POWYS COUNTY COUNCIL

# Mynydd y Gwynt Wind Farm

## Written Representation

APPLICATION REF: **EN010020**

**FIGURE 6.2**

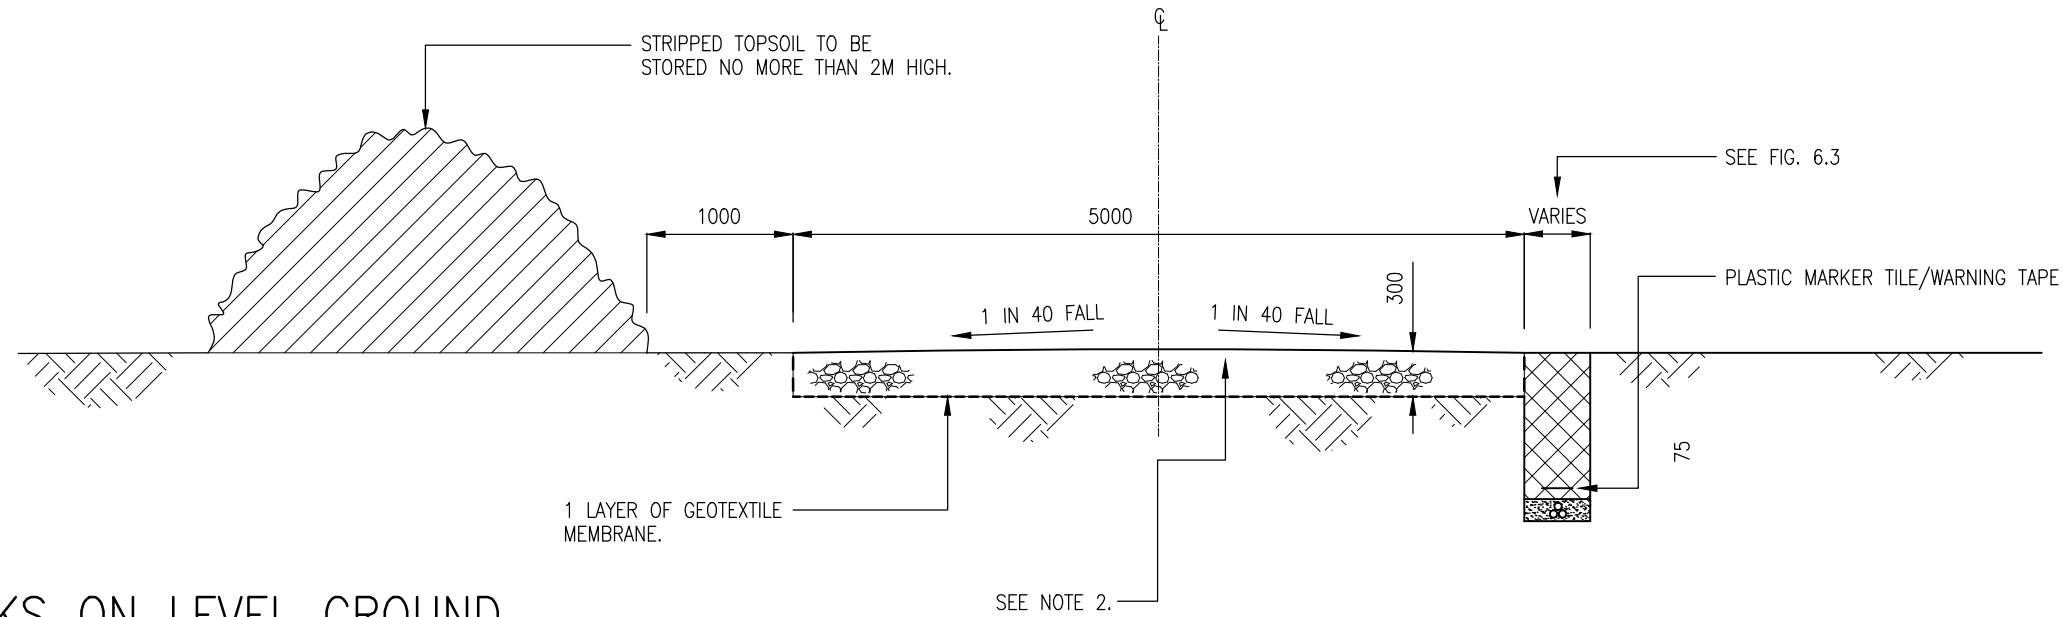
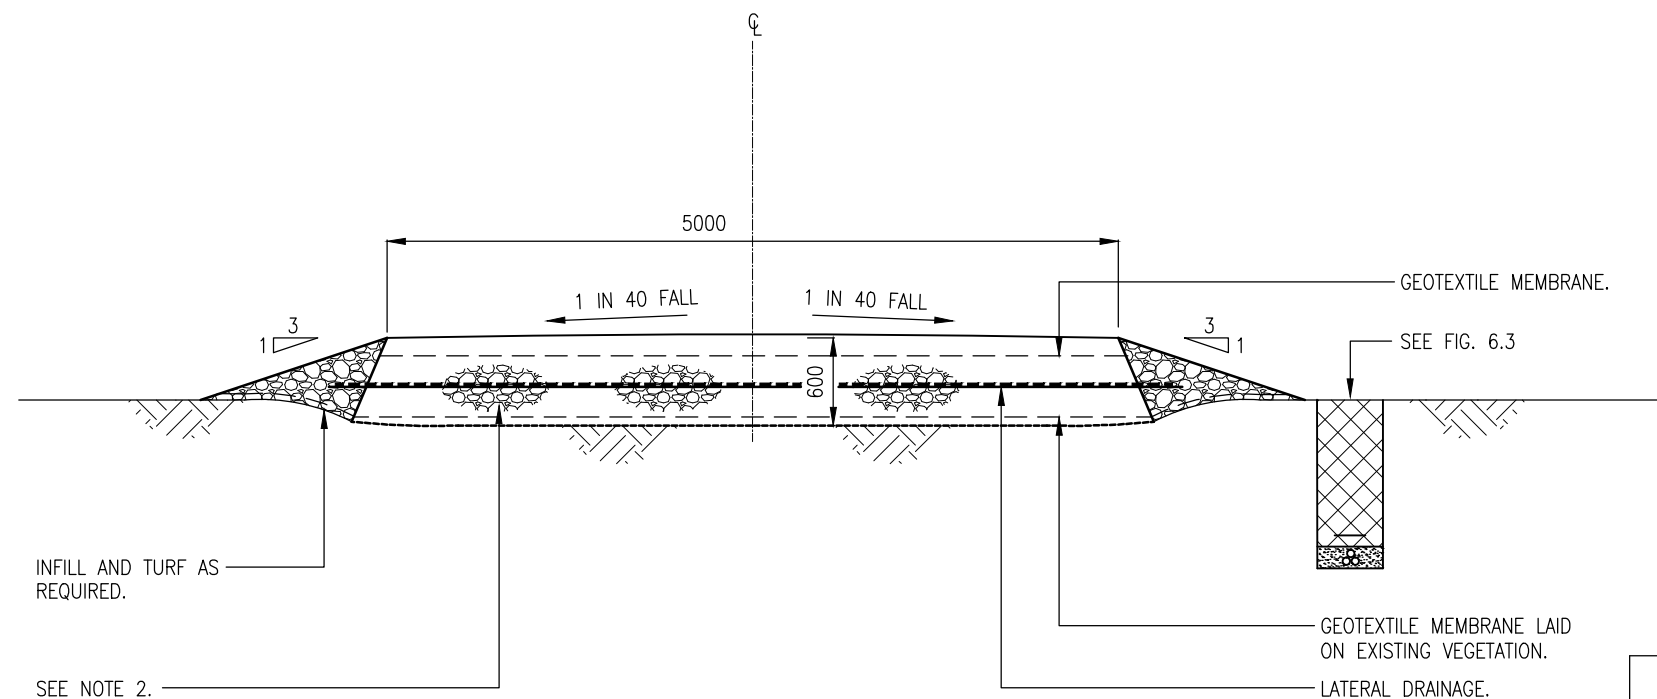
- Chapter 6.10 states that the new tracks will have topsoil stored to the side and the LIR highlights that this could obstruct public rights of way; this is unacceptable and where a public right of way is to be crossed by a new track the path should not be obstructed or access hindered in any way.

FIGURE 6.9

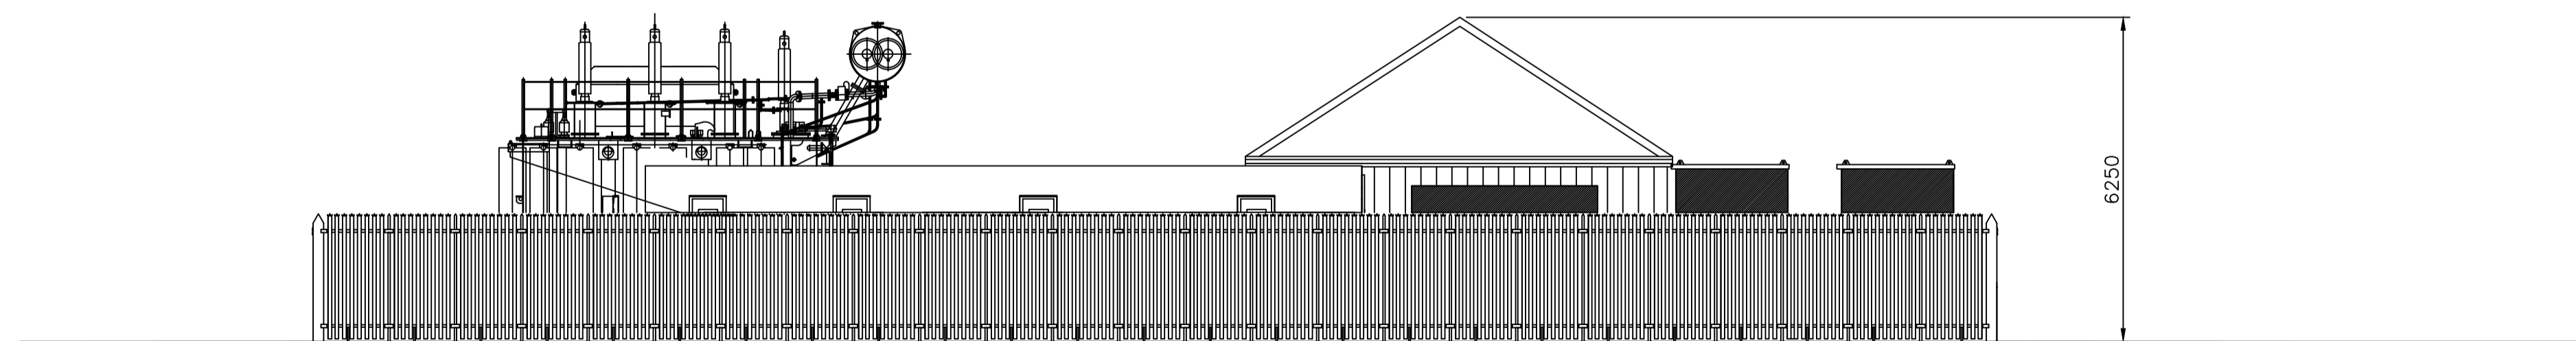
- 3.36. The location of the substation is of concern. It appears that the proposed substation is very close to the line of bridleway 49.
- 3.37. Taking these matters into consideration this application would result in unacceptable negative impacts on the Wye Valley Walk and the public rights of way network, with no mitigation or enhancement being offered to offset those impacts, and the location of the substation in relation to bridleway 49.

Figure 8.10b

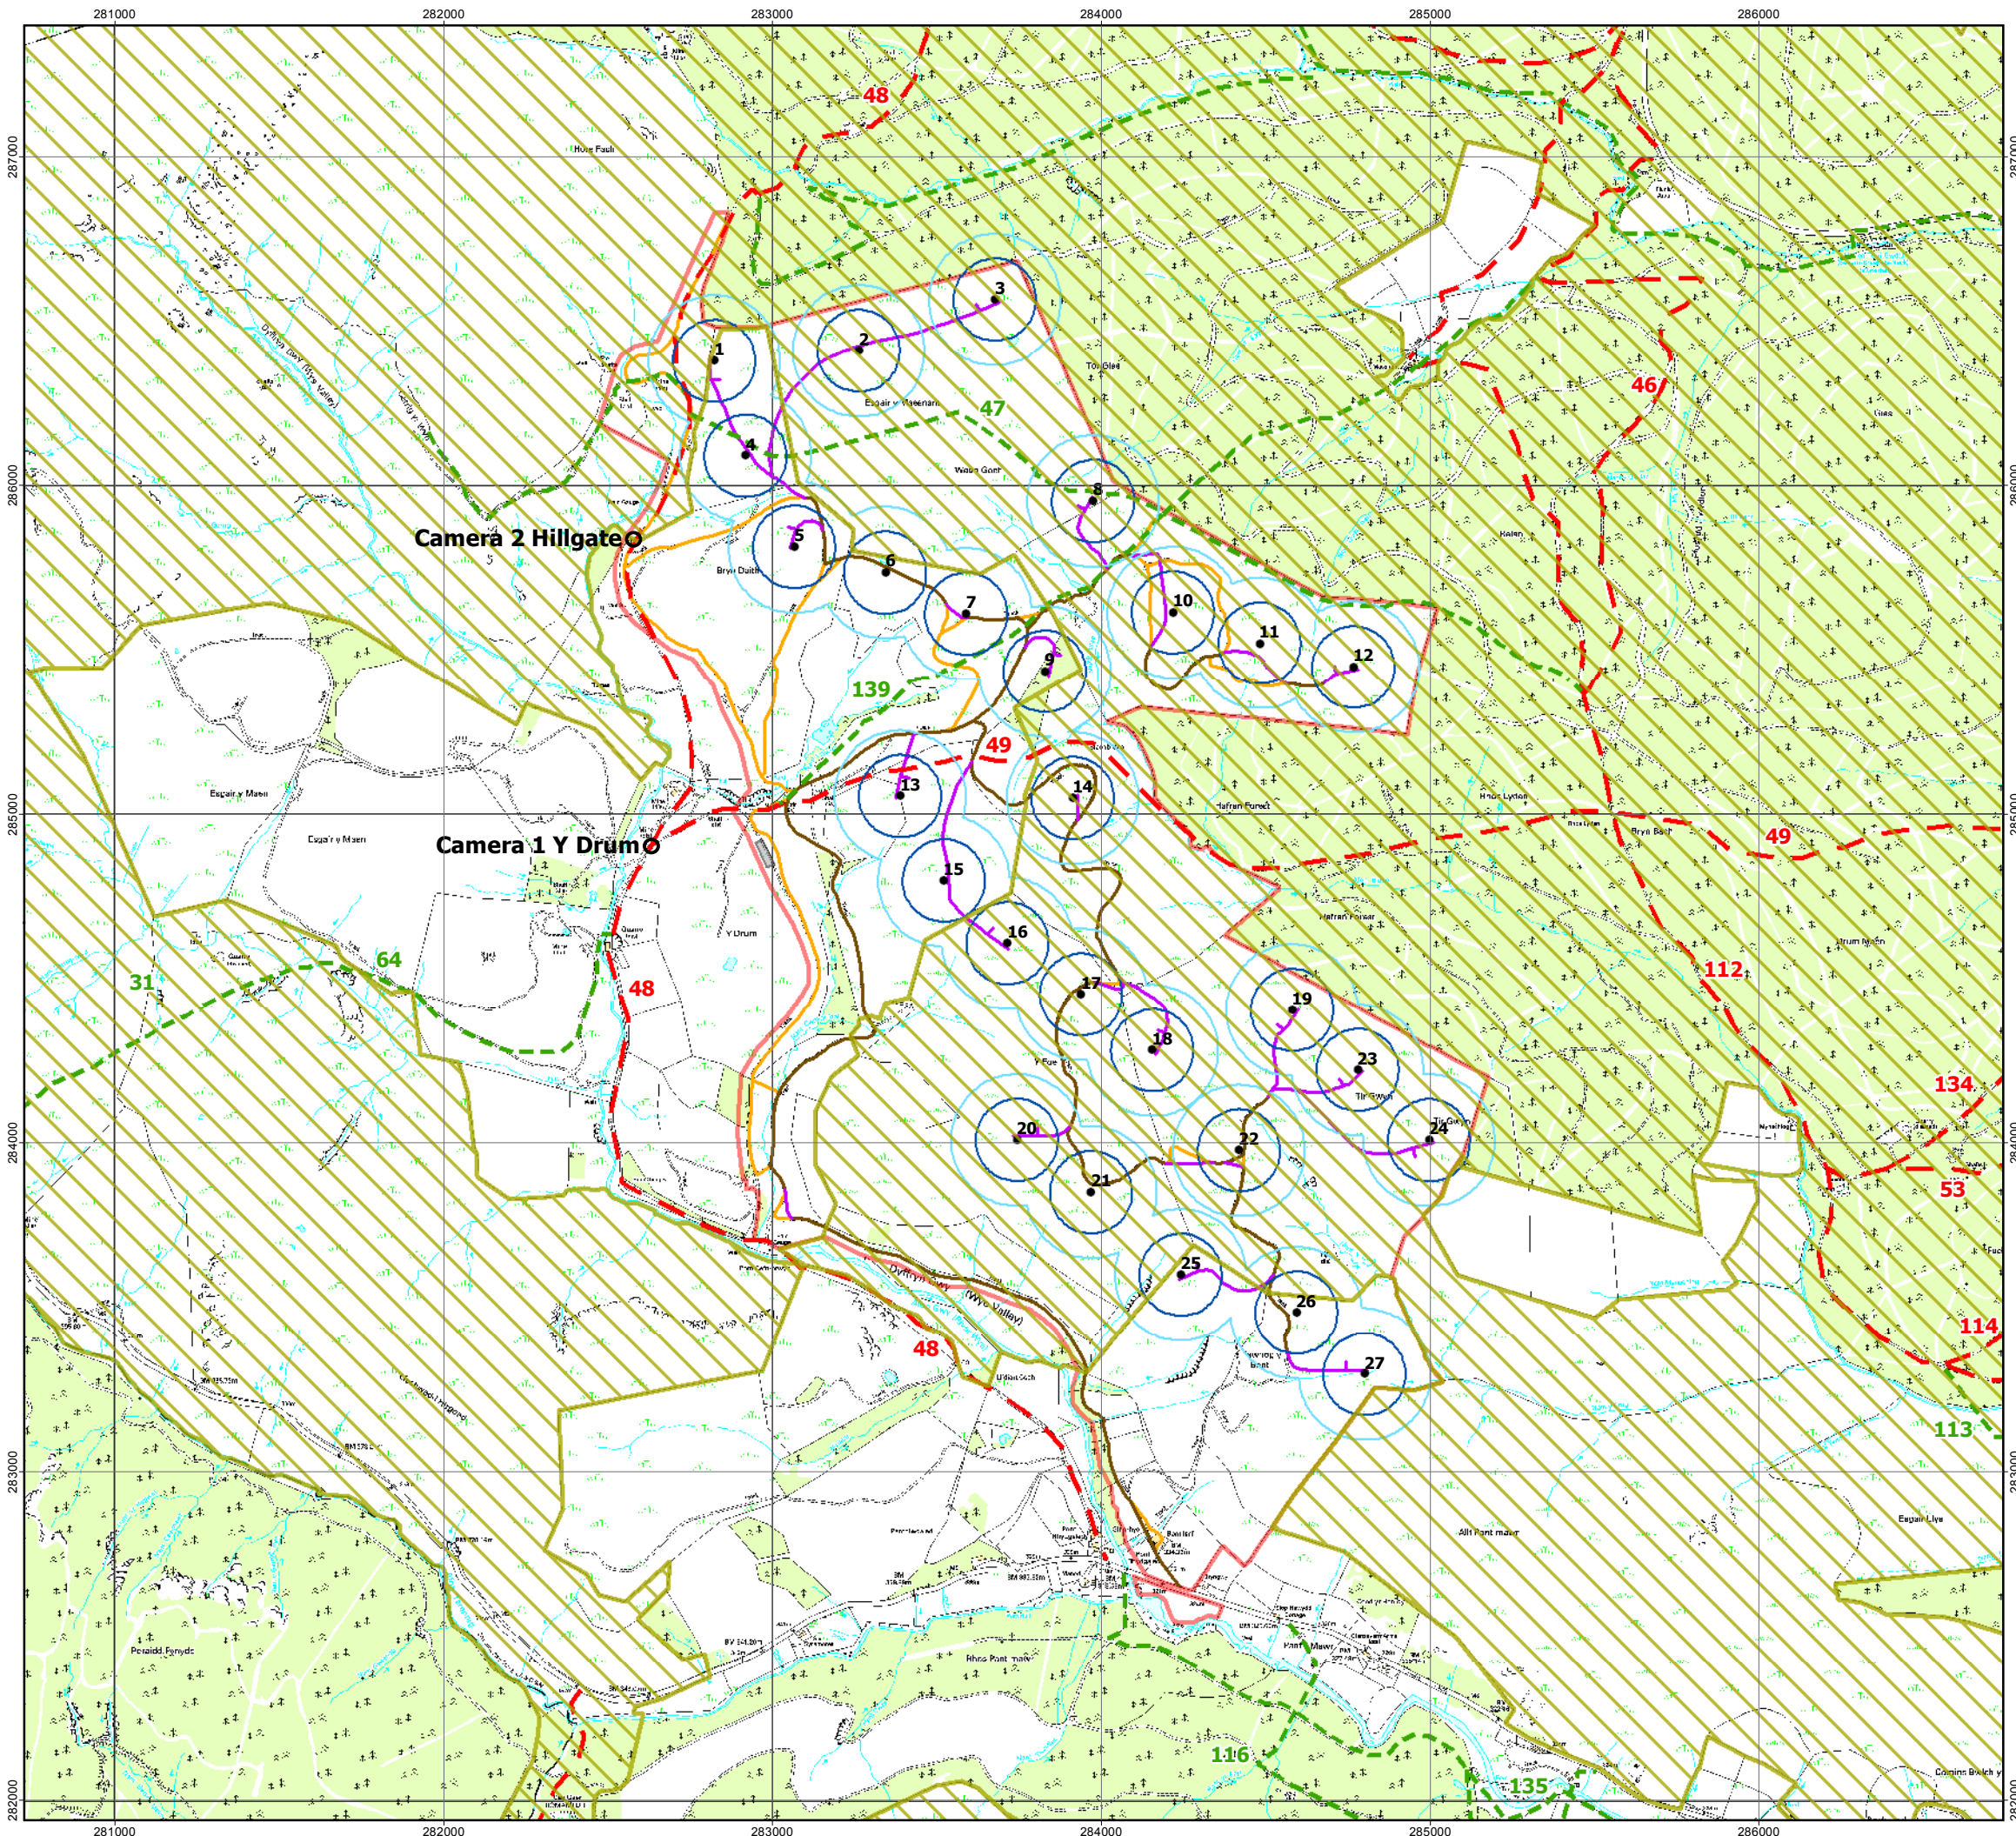
- 3.30. PCC seeks to ensure that turbines are kept a minimum of tip height from footpaths (125m in this instance) and 200m from all paths of a higher status (bridleways, restricted byways and byways open to all traffic). The LIR highlights that turbines 1, 4, 7, 8, 13 and 14 fail to meet these distances.
- 3.31. PCC considers that these turbines that are too close to public rights of way would have an unacceptable adverse impact to the users of the public rights of way. Turbines 4 and 8 for

example would be under the swept diameter of the blades. Chapter 8.137 acknowledges the proximity of Turbine 1 and Turbine 13 to bridleways but fails to mention the turbines in extreme proximity to footpaths.

- 3.32. It is noted that the applicant has requested a micrositing buffer of 50m. If this were to be implemented, Turbines 4 and 8 could be placed on top of a public right of way, which is unacceptable. We request that micrositing of a turbine should not be permitted where this would move a turbine closer to a public right of way and that this should be secured through an appropriate requirement.
